17 November 2011

Re: Section 75W Modification Application - Stage 1 Project Application Residential and Child Care Development (MP10_0177 MOD 4)

Figure 4: Existing intersection of Pittwater Road and Warriewood Road (Source: Google Maps, 2012)

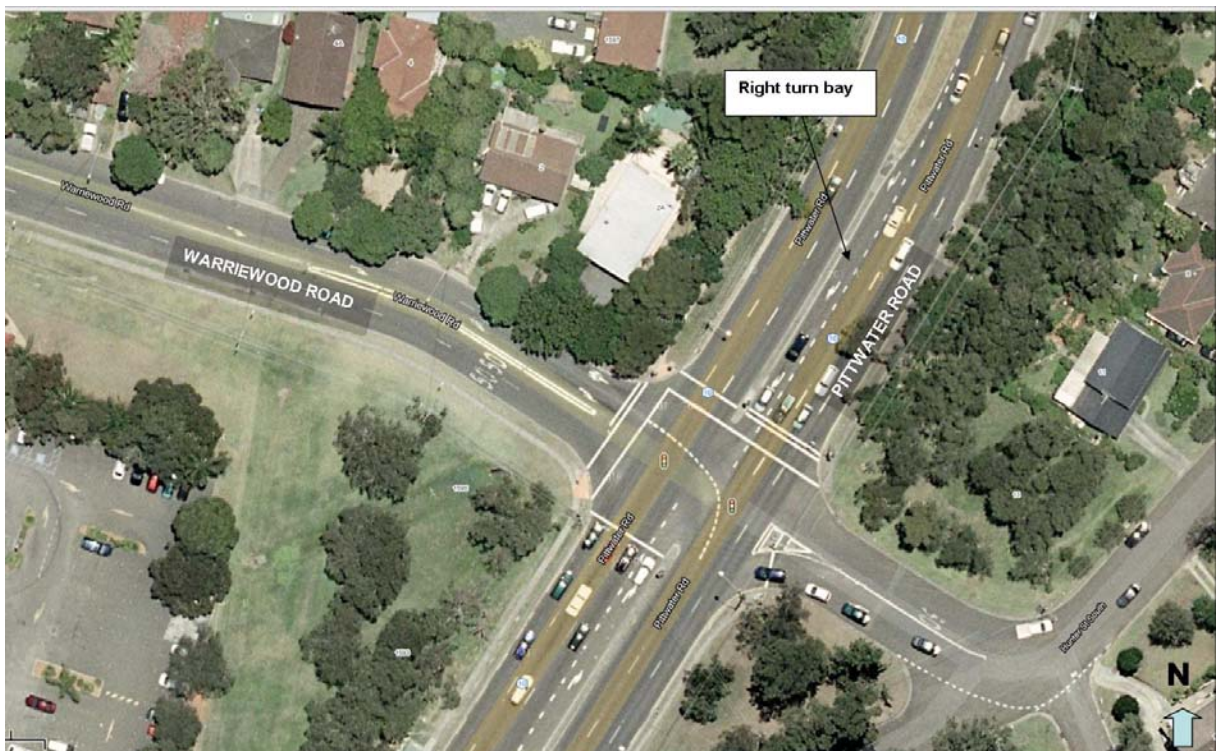
It is considered that the extension of the right turn lane in Pittwater Road at Warriewood Road is a critical piece of infrastructure upgrade that was directly necessitated by the approval of the subject development. The increased traffic volumes necessitating this upgrade are a direct result of the higher development density approved for this development over the density on which the Warriewood Valley Roads Master Plan – 2006 Review (WVRMP) was based.

This report identified (Pg 8) that the right turn bay in Pittwater Road at Warriewood Road prior to the approval of the development was operating *"close to capacity, with the right turn bay in Pittwater Road currently overflowing onto adjoining lanes on occasions during peak hours"*.

Following consideration of the Meriton Development Application and the Assessment of Traffic Impacts report by Halcrow, the RTA provided a recommendation (No 3) that was included by the PAC as Condition of Approval F15.

"As indicated within the Halcrow report, the right turn movement from Pittwater Road into Warriewood Road at the intersection of Pittwater Road/Warriewood Road/Hunter Street currently overflows into the through traffic lanes. To address this issue along with the increased turning movements associated with (Stages 1 & 2) of the development, the

developer will be required to lengthen this right turn bay to provide a minimum of 80m storage +taper."

- Condition C6 can be modified
- Condition F15 should remain and be the responsibility of the developer (Meriton) to provide.
